Drawing Title				
FIGURE 5.5A RECEPTOR LOCATIONS AND NO₂ RESULTS FOR OPERATIONAL LOCAL AIR QUALITY ASSESSMENT				
Designed	DW	Checked	Approved	Date
MH	GB	MH	SW	29/03/19
Internal Project No		Suitability		
60533462		D7		
Scale @ A3		Zone

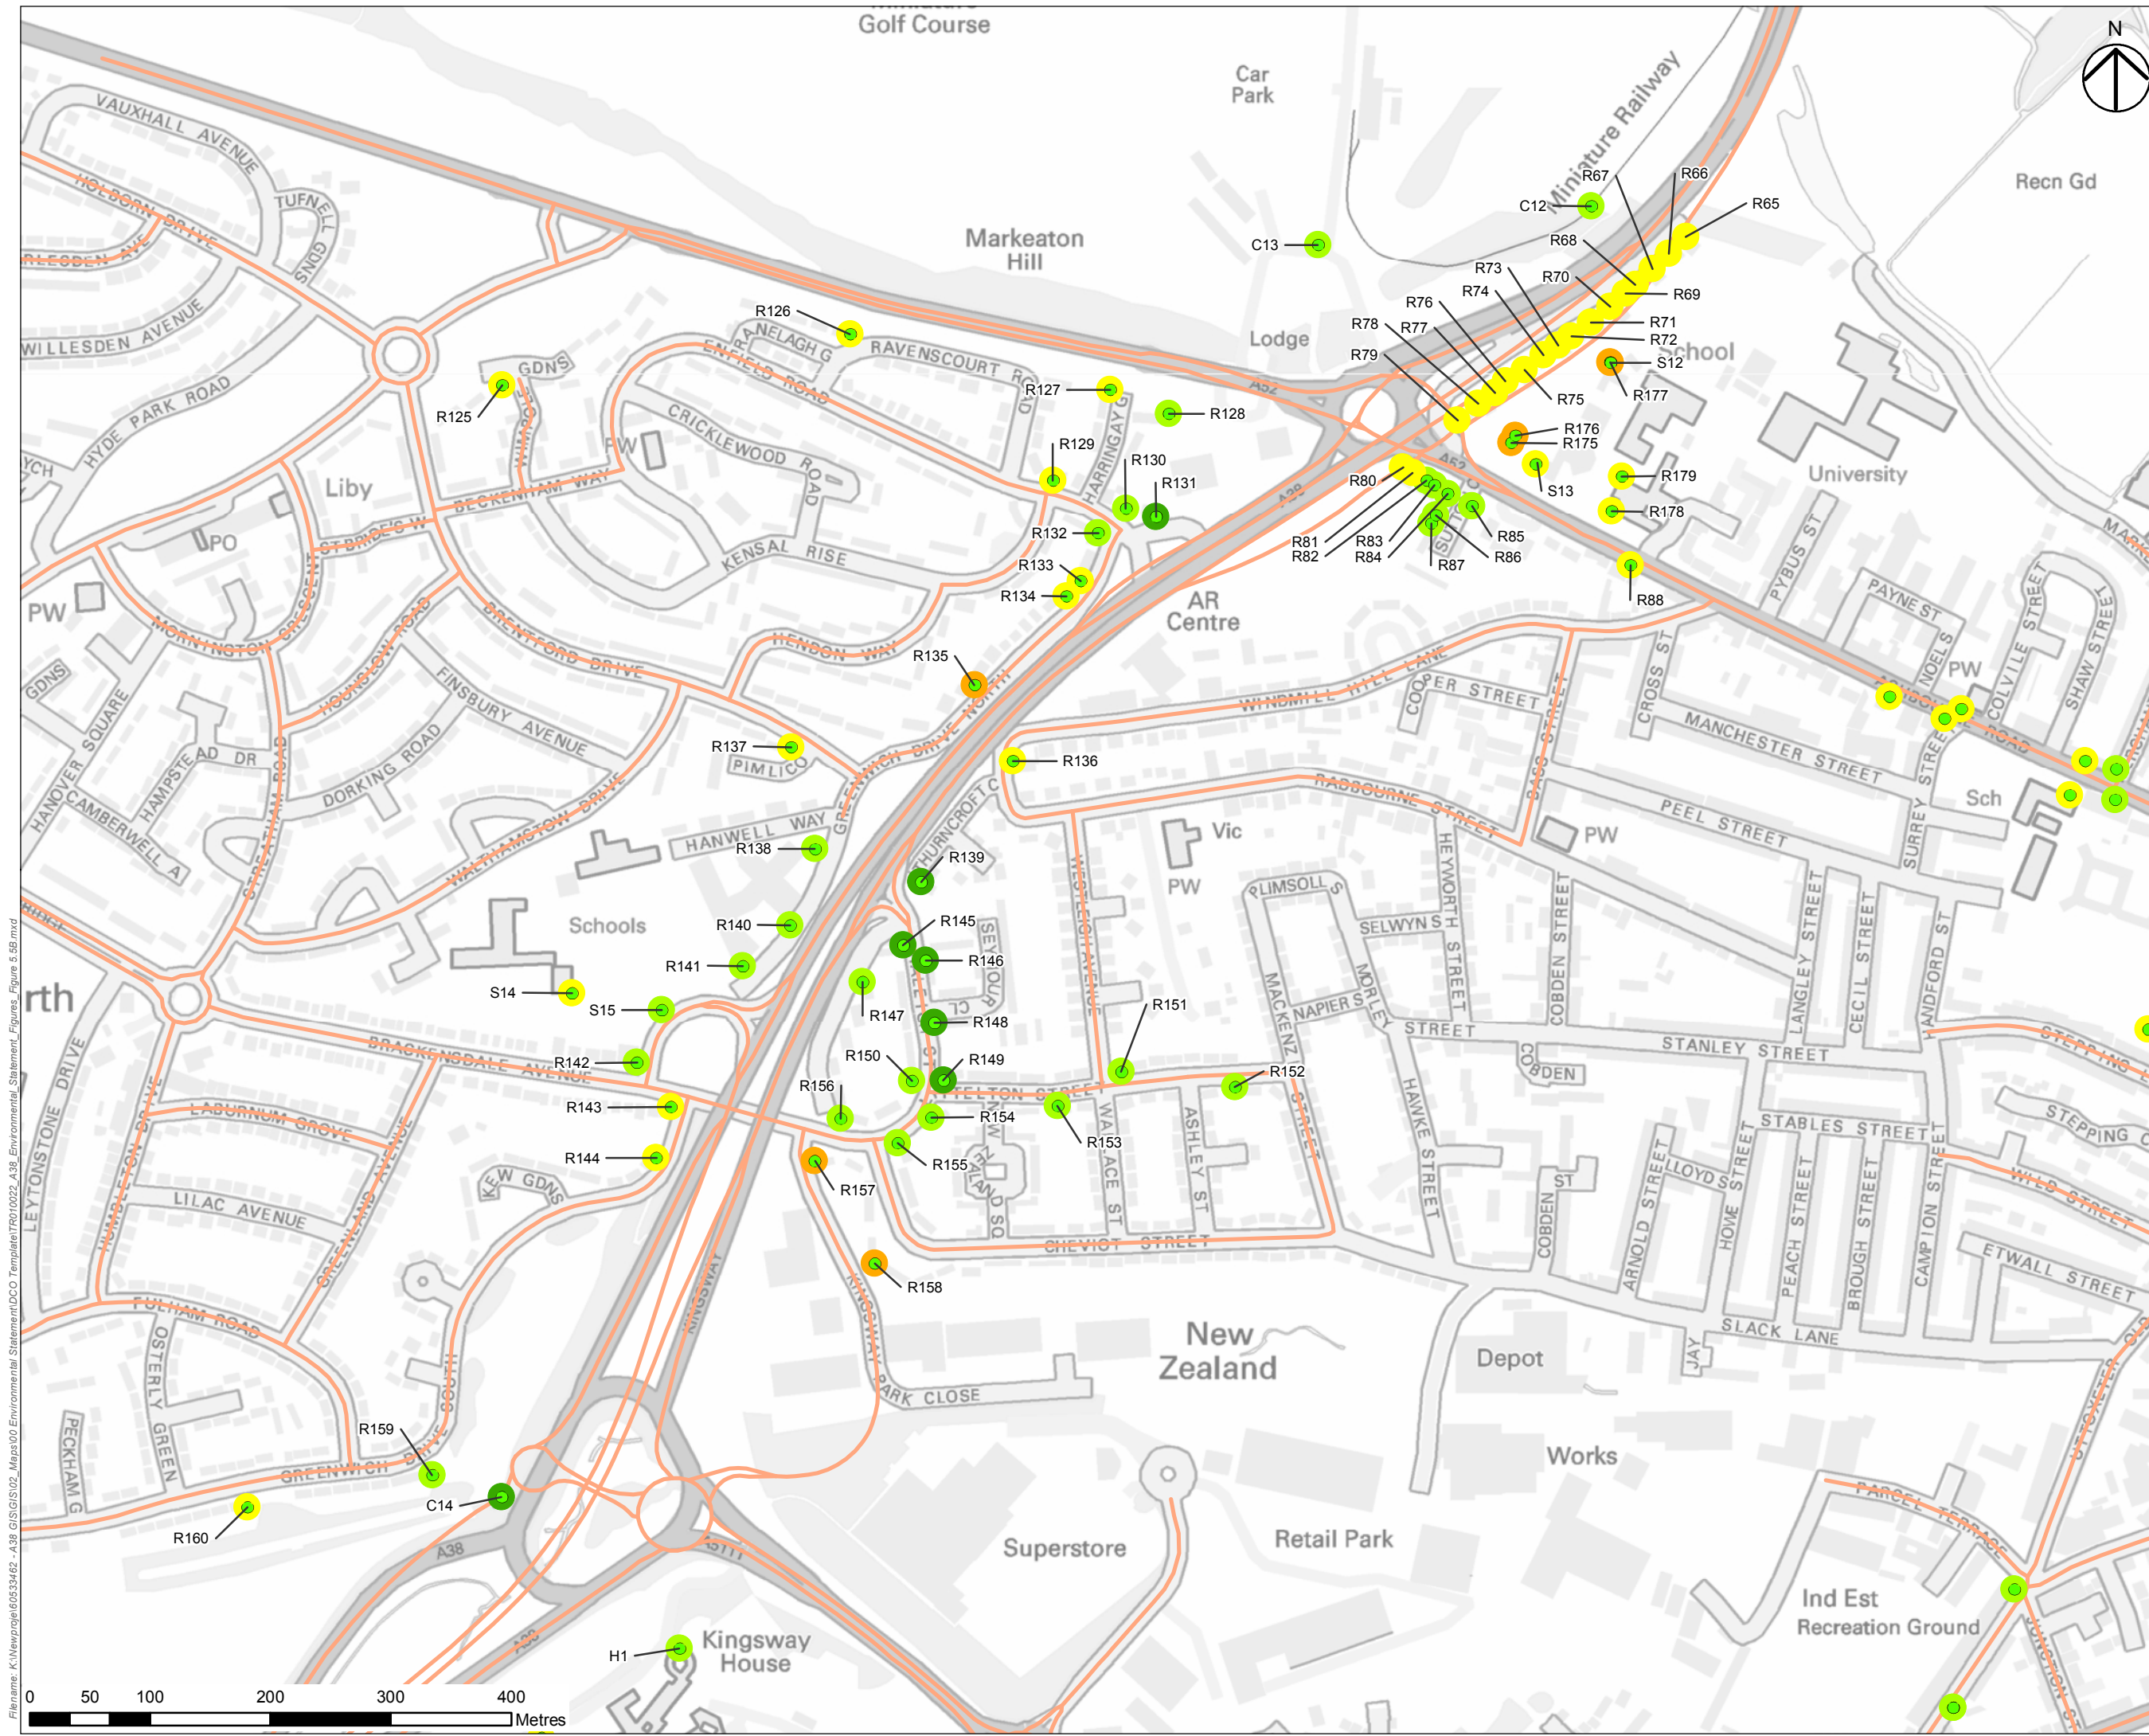
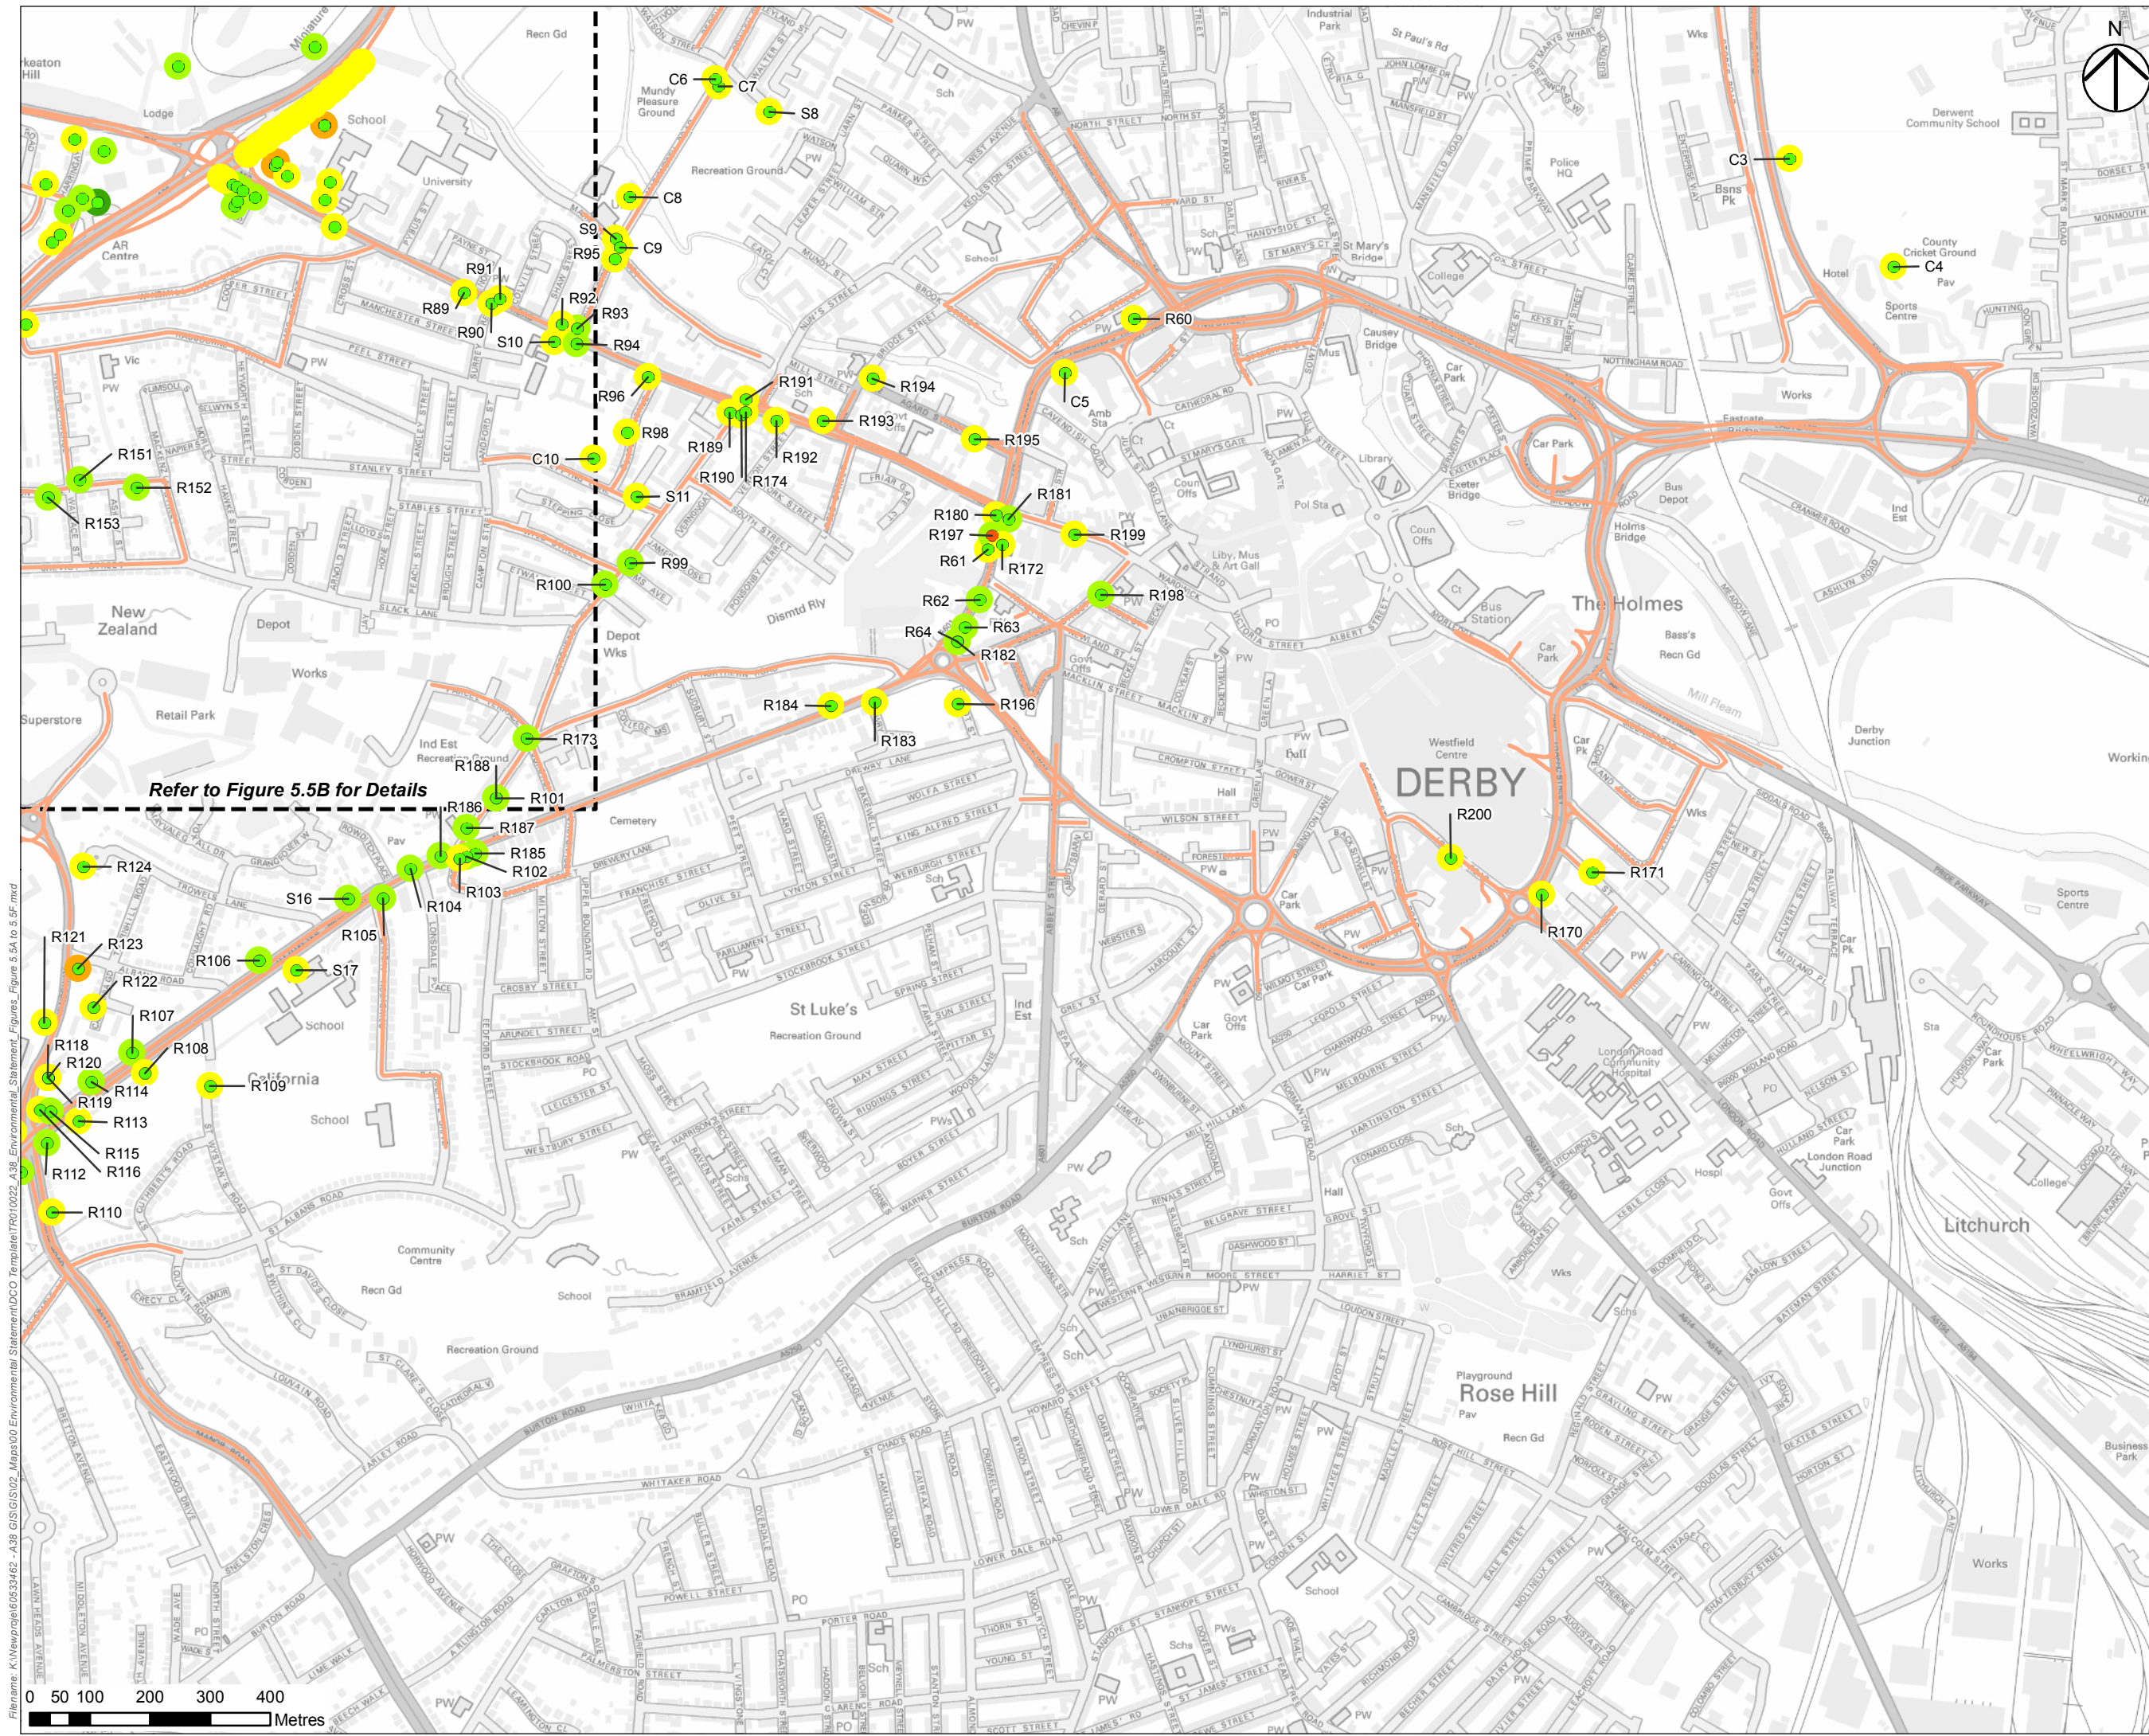
Q39 There are large disconnects between various HE claims. For example, in responses to Derby Friends of the Earth (REP6-035, Vol 18.84) the following statements are made, re Stafford St "With operation of the scheme, improvements in air quality are also expected in Stafford St" and "operation of the scheme is also expected to reduce traffic flows in Stafford St and this will be beneficial for air quality"

However, answering Q24 (REP6-025) "as detailed in ES para. 5.10.62 of ES Chapter 5: Air Quality [APP-043], reduced NOx and PM10 emissions are expected in 2024 both with and **without** the Scheme as compared with the baseline (2015)." HE 8.86 Supplement to Air Quality Assessment Risk, Table 1 clearly shows NO2 limit value exceedances (see also National Friends of the Earth evidence, pg 4, Derby Friends of the Earth HE Response, 3 A38)

Q42 In response to FOE (REP6 035, Vol 18.84) re Stafford St "NO2 concentrations will be within the limit value both with and **WITHOUT** the scheme" Therefore, there is no clear benefit of the scheme
